Orsted Onshore Ireland Midco Limited

4: MEMORANDUM RESPONSE TO SUBMISSIONS RECEIVED

ORNITHOLOGY

Proposed Oatfield Wind Farm Project, Co. Clare: ABP
Case No. ABP-318782-24

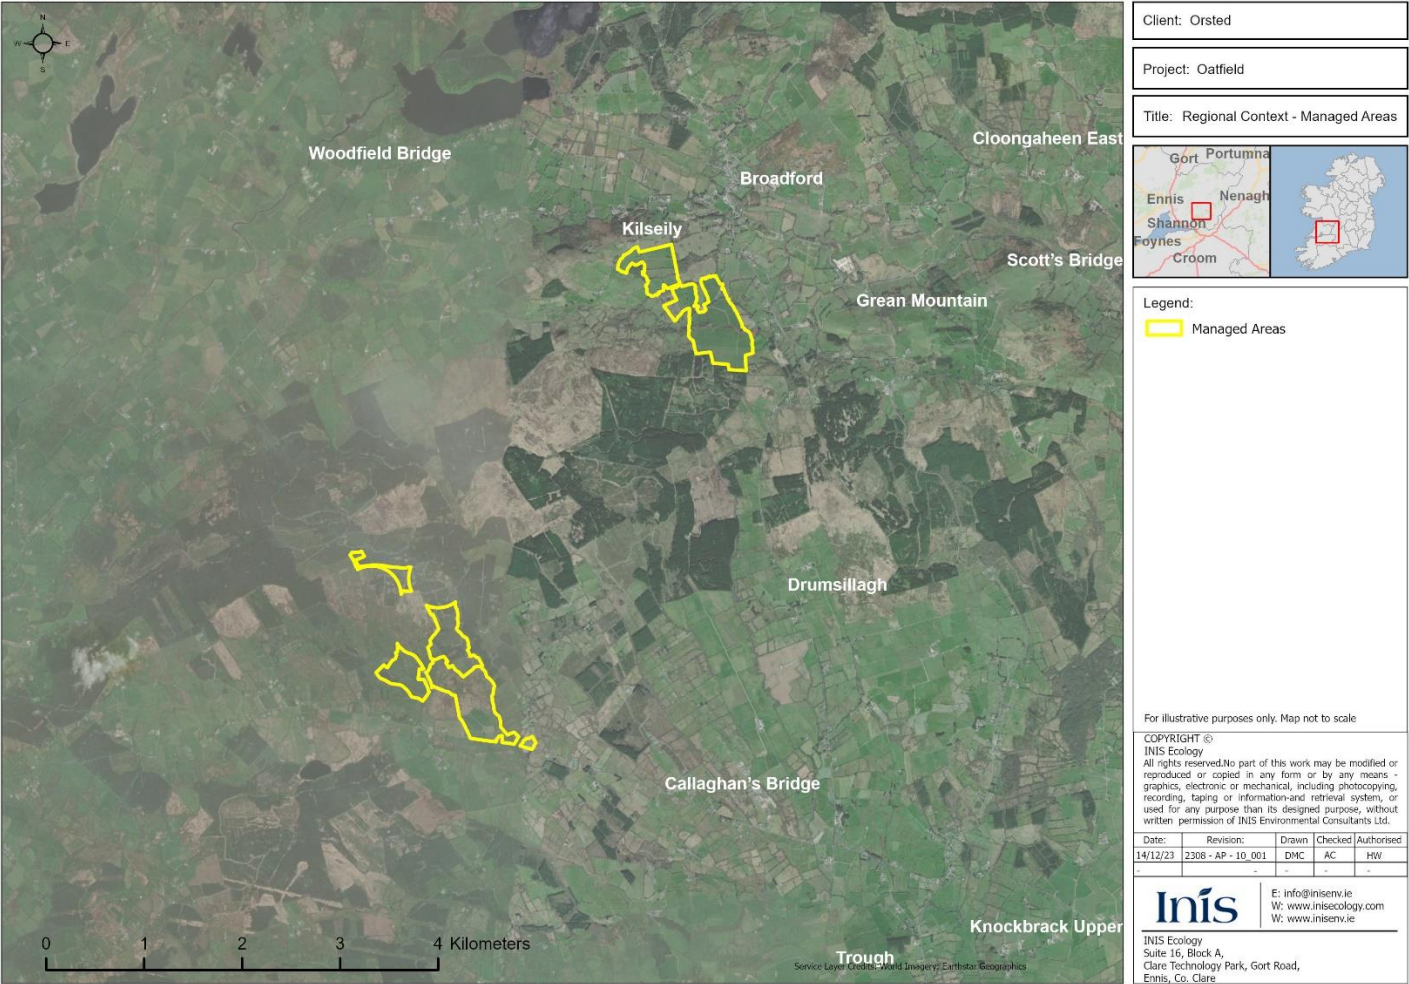
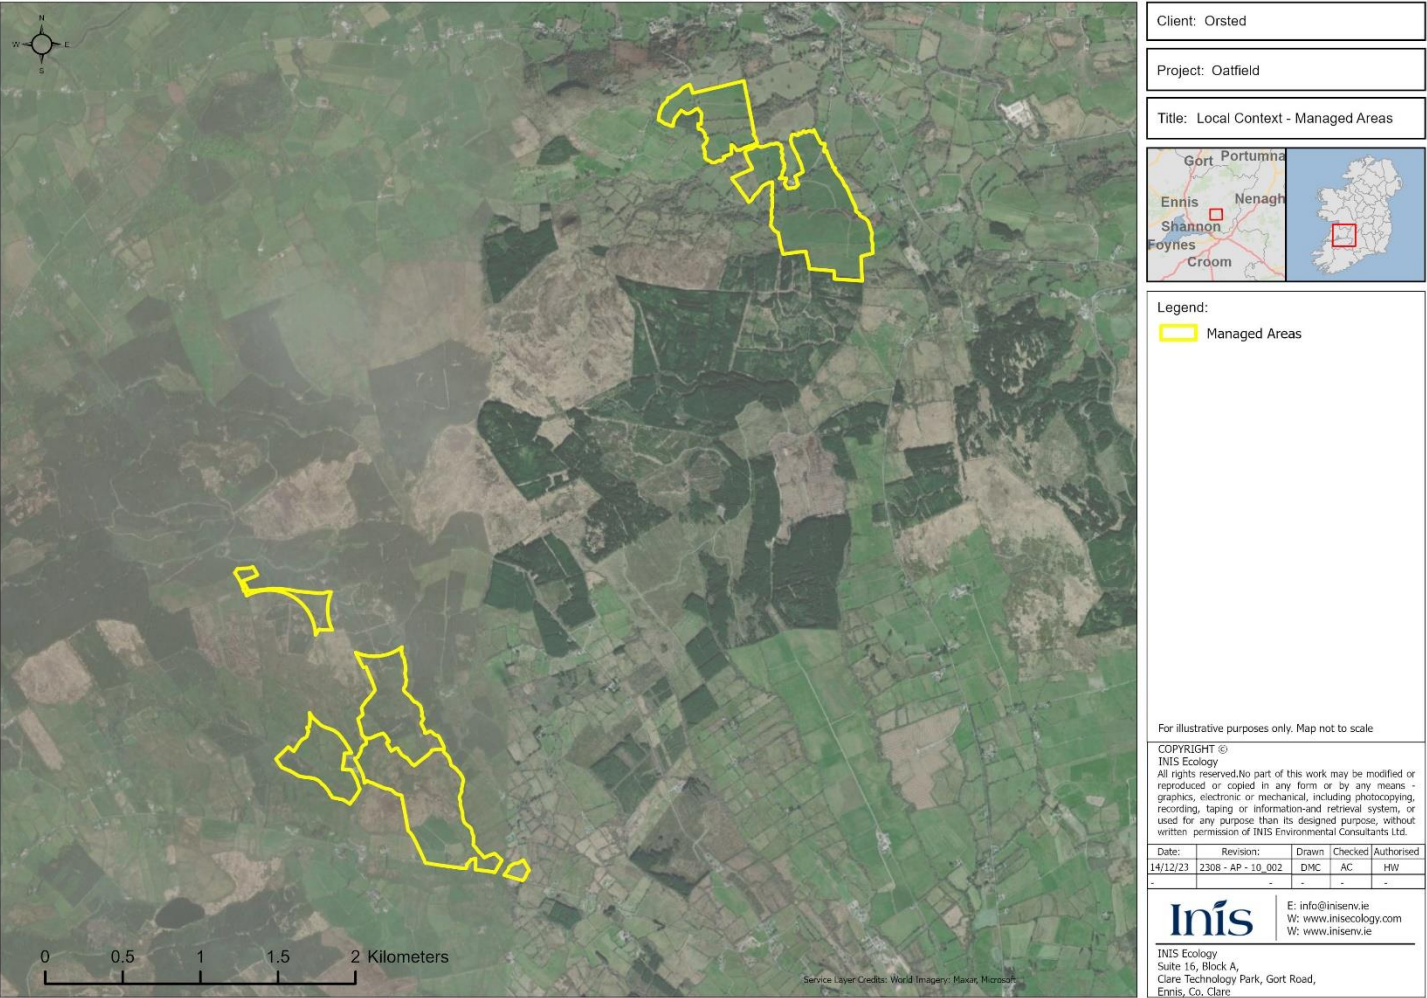
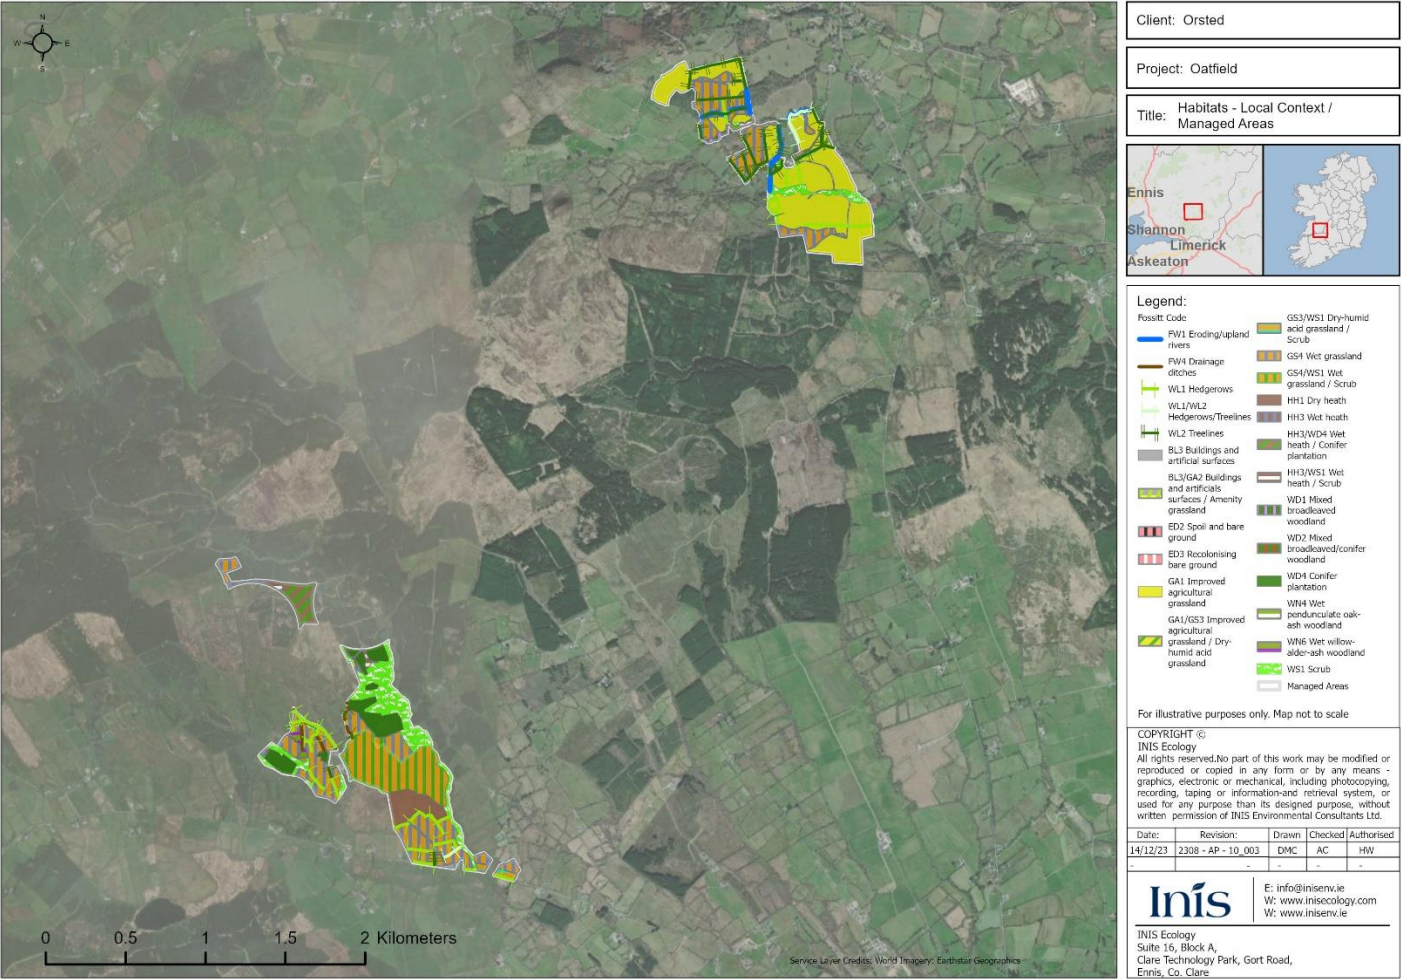
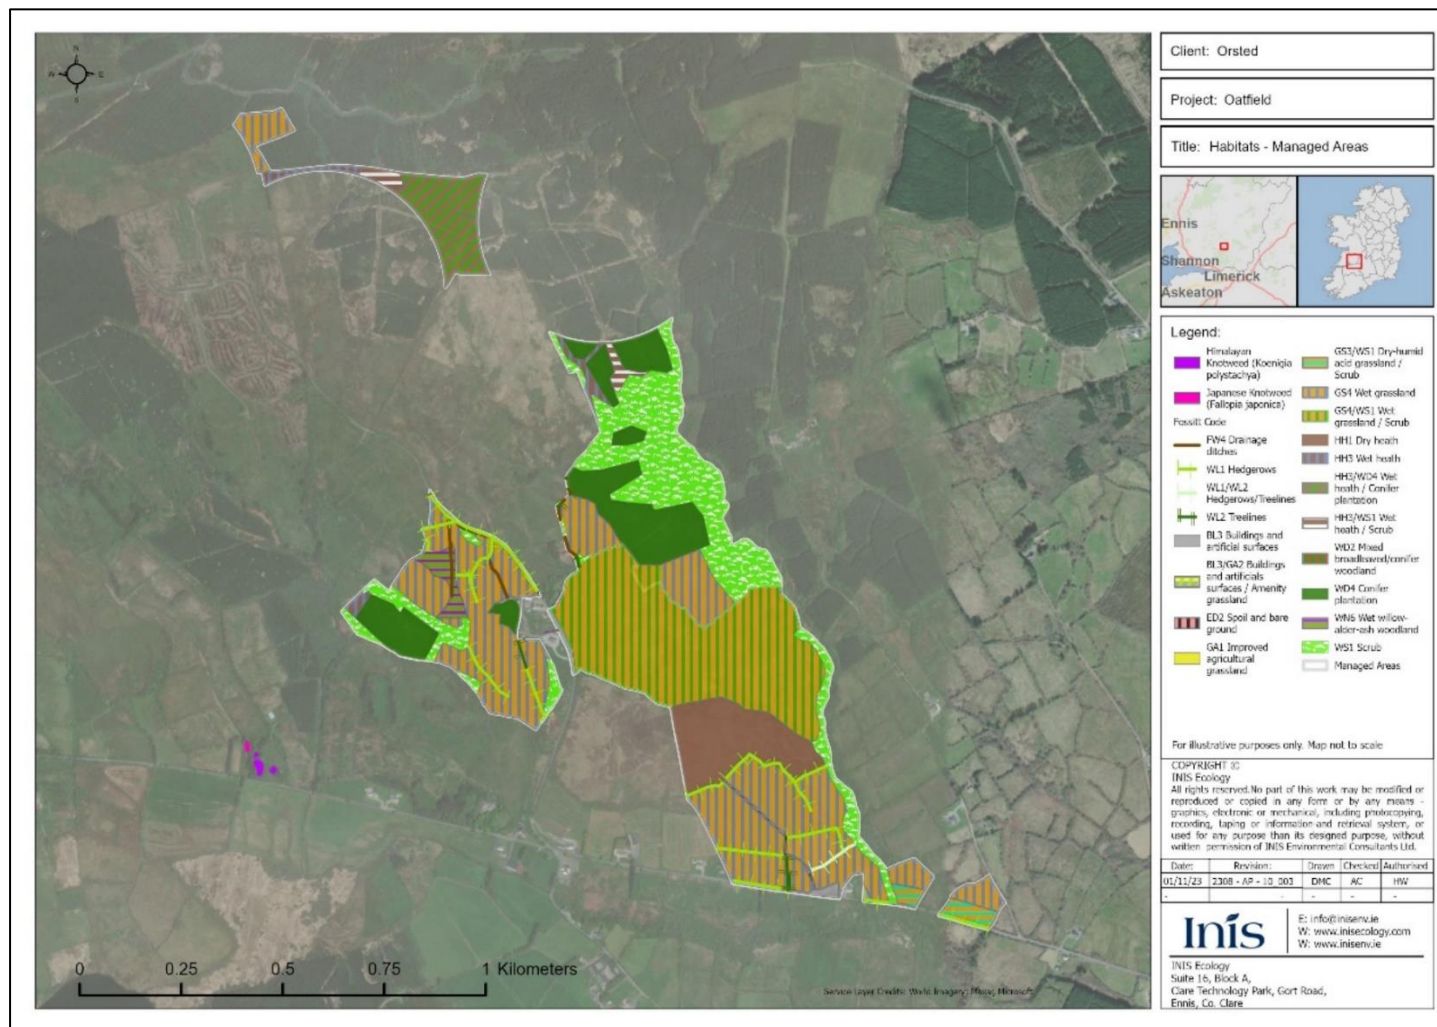
The version of the SHMP submitted in December 2023 (see **Appendix 7.1** of the **EIAR Chapter 7 Biodiversity**, hereafter referred to as **EIAR Chapter 7**) indicated an area of land not within the landowner agreement schedule (i.e. Figure 1.20, Figure 1.21, Figure 1.22 and Figure 1.24). This was purely a presentation matter and calculations regarding adequacy of compensatory habitats etc. were correct in the original submitted document. The figures referred to above have since been amended in an updated SHMP which can be found in **Appendix 2 of the Biodiversity response i.e. memorandum no. 3** of the submission response documentation).
